DEVELOPMENT PLAN FOR
SECURITY FIRE STATION NO. 4
 0 Mesa Ridge Parkway
 Security, CO

FINAL LANDSCAPE PLAN

**RE: Request for Alternative Landscape Design.
Development plan: Security Fire Station No. 4**

SHEET NO. **LS-1**
 Sheet 1 of 2

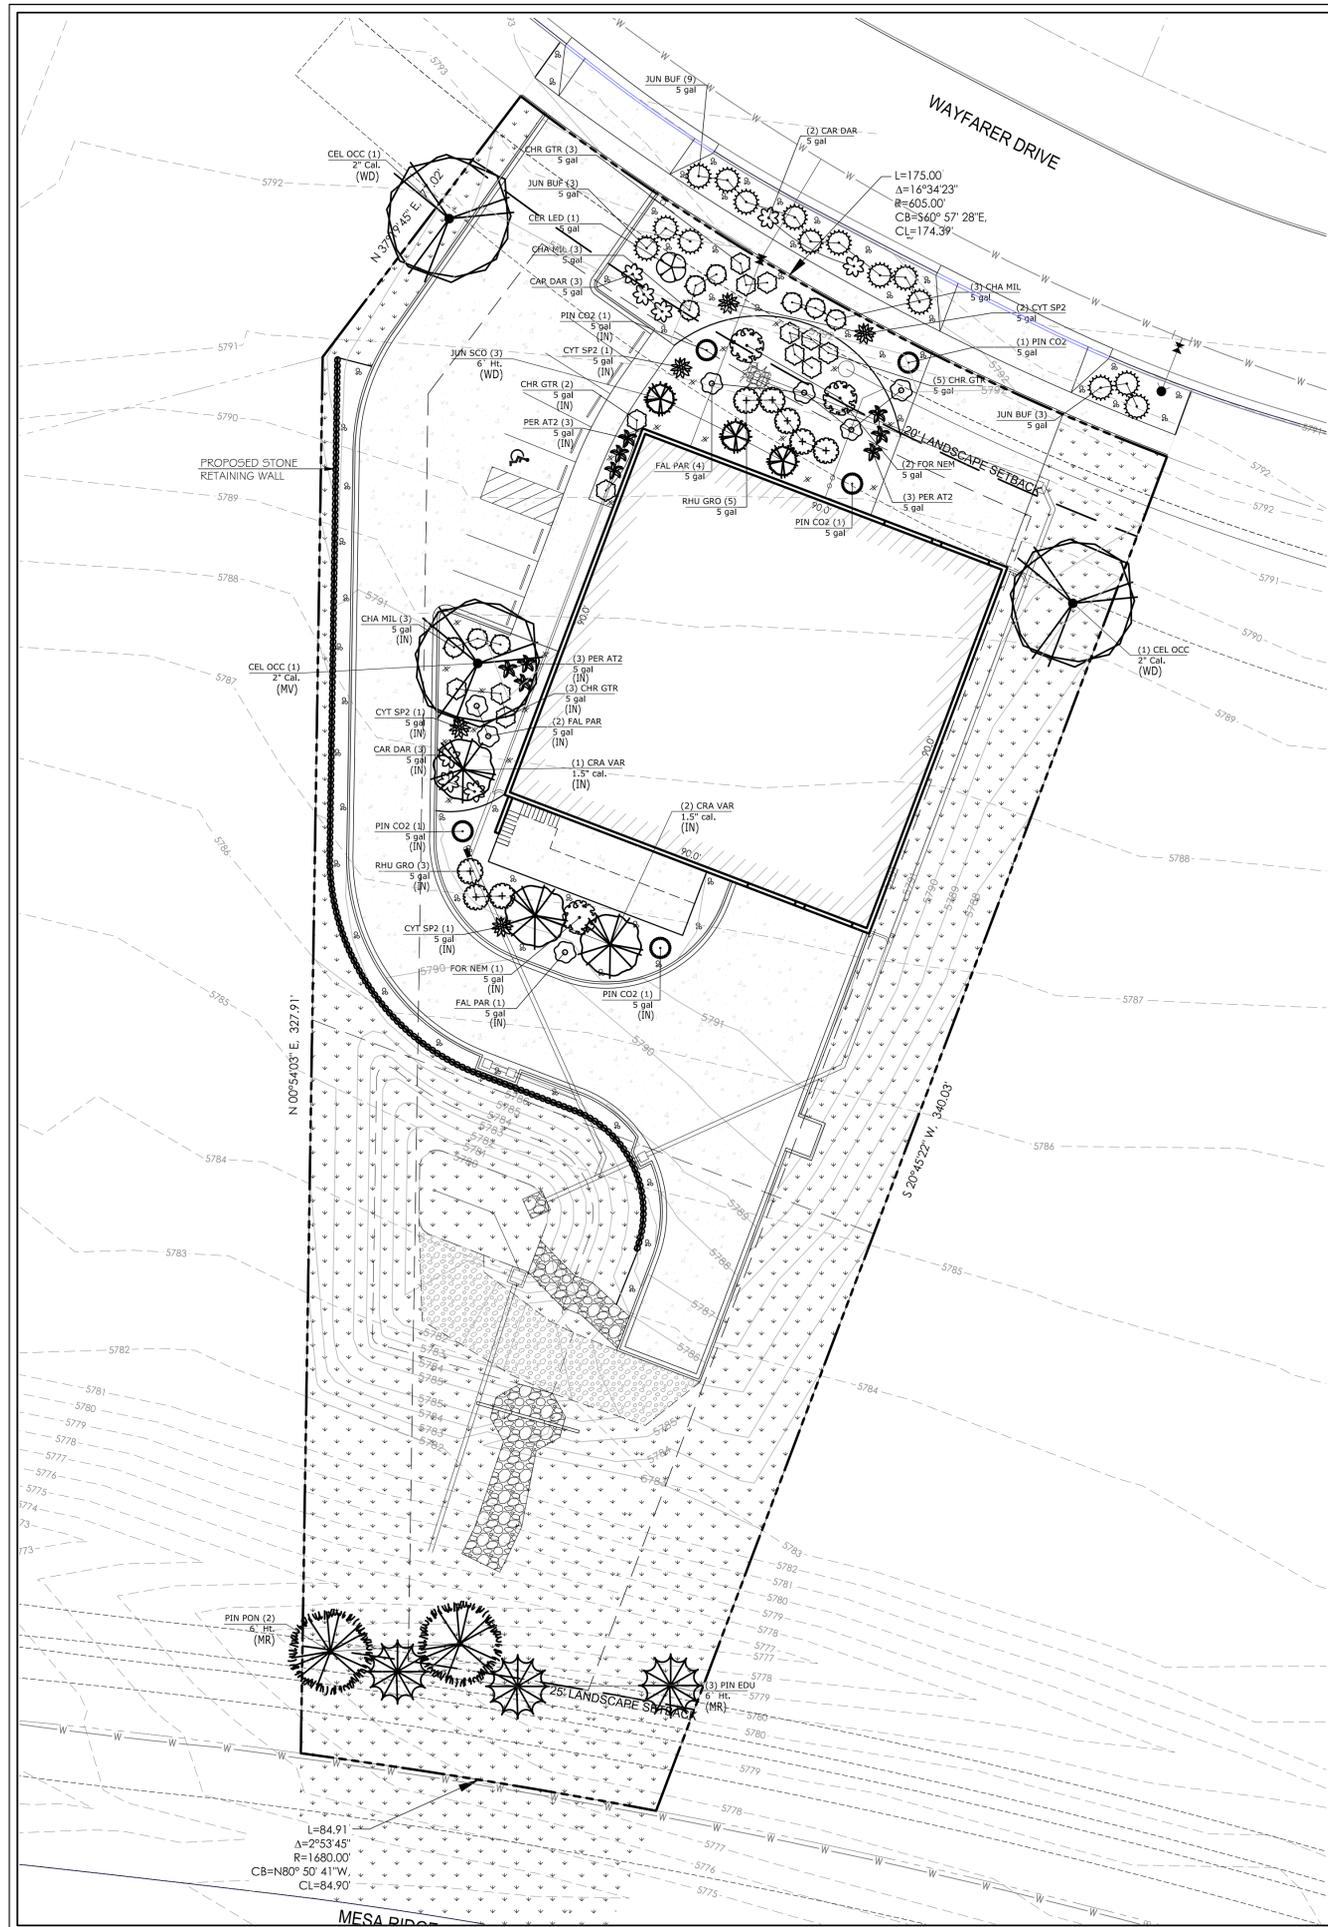
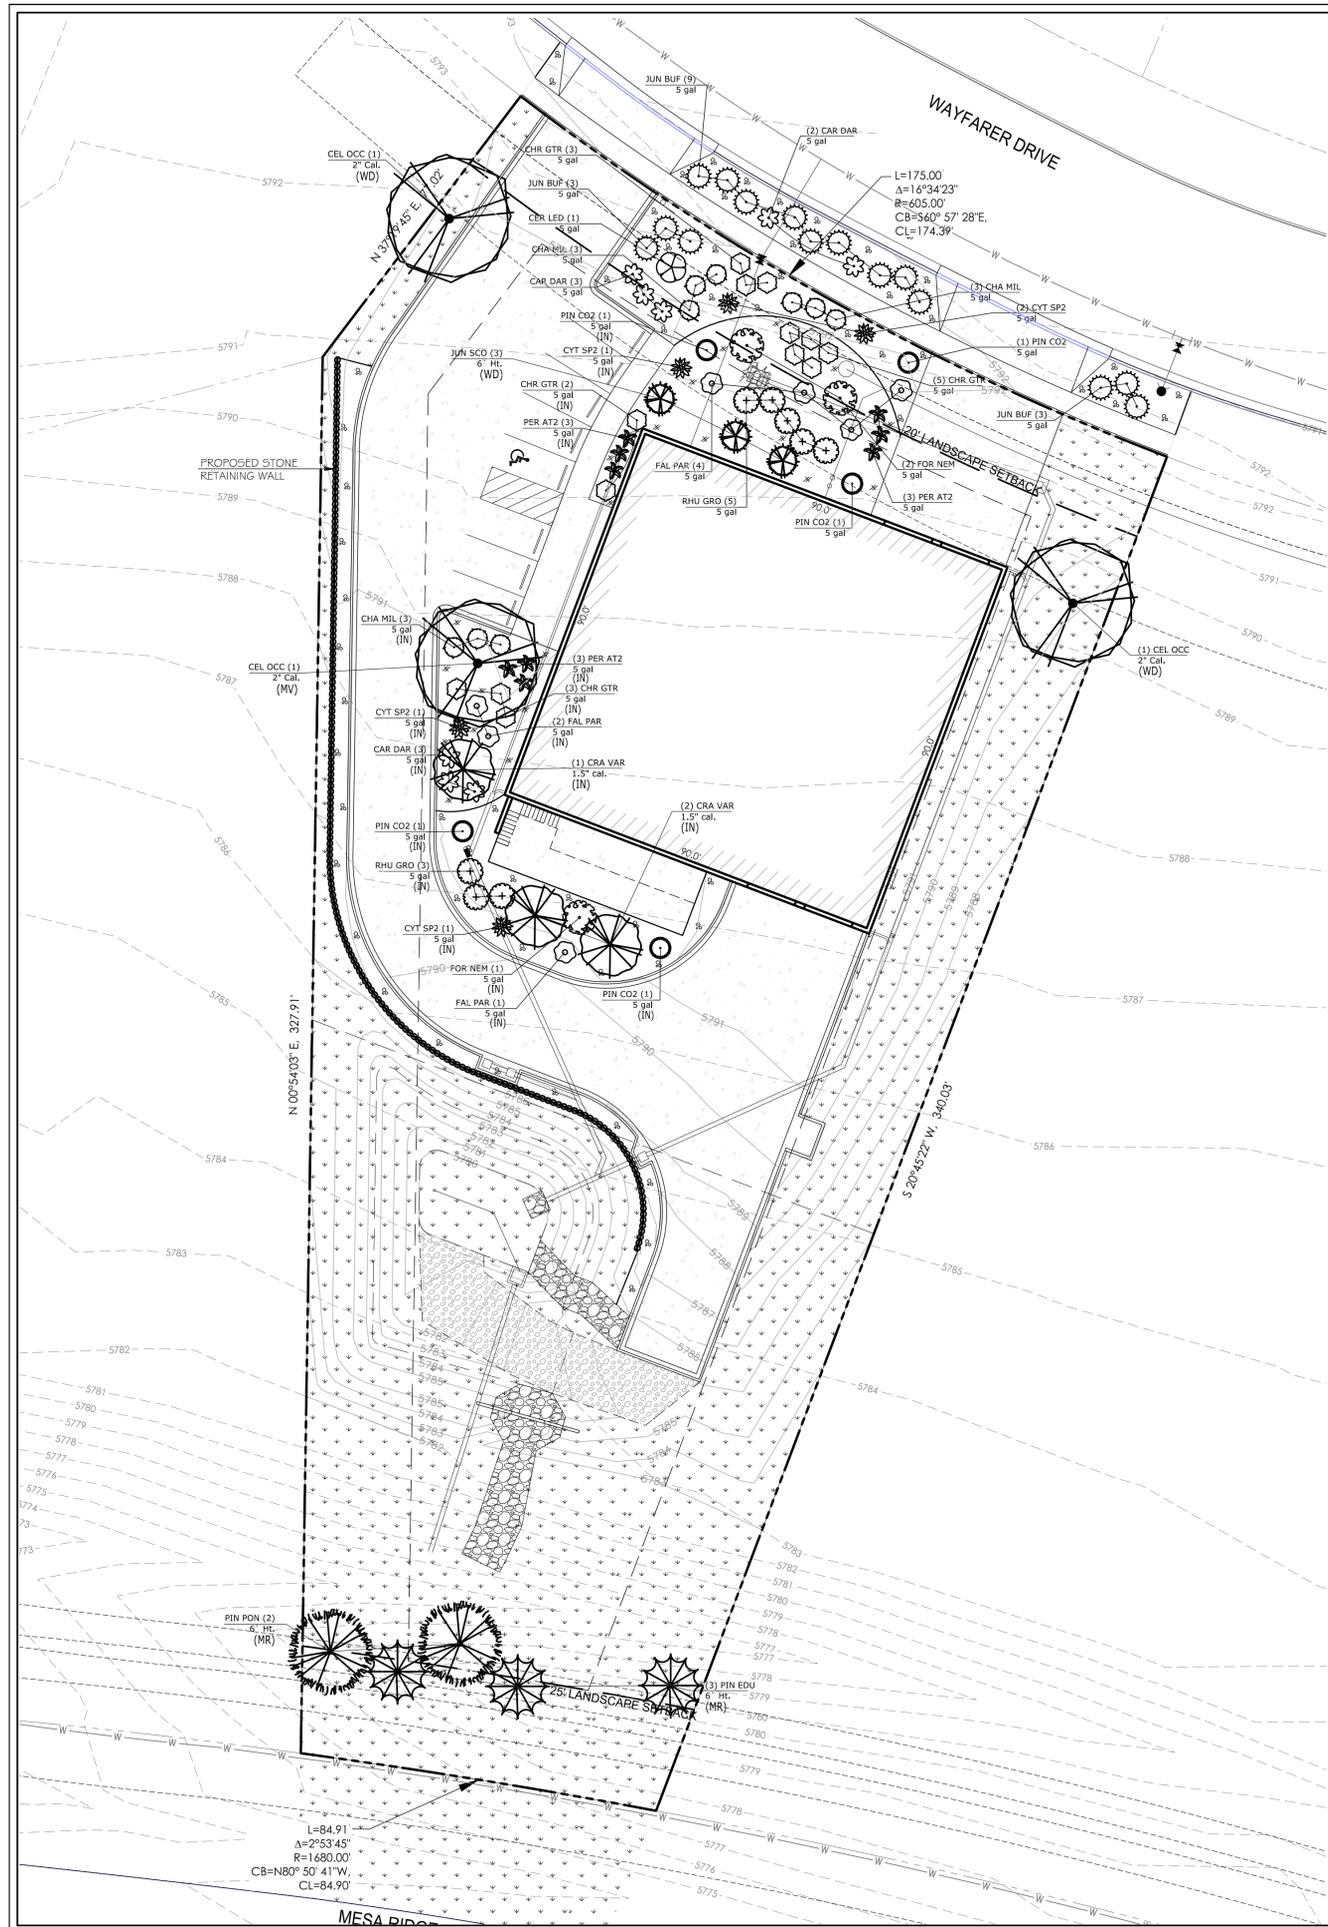
Trees need to be taken out of the right of way and planted on the property within the landscape buffer area.

Please explain. See also alternative landscape comment. Shrubs may only be replacements for trees for retail storefronts and only 1/2 of required trees may be replaced by shrubs.

Please provide justification in letter of intent and on this plan for alternative landscaping request. If criteria in LDC Sec. 6.2.2 regarding alternative landscaping cannot be met, please revise to provide the required number of trees.

This justification needs to be in letter of intent. Please review the criteria in Section 6.2.2 relating to alternative landscaping and justification requirements. Contact PCD Project Manager with questions.
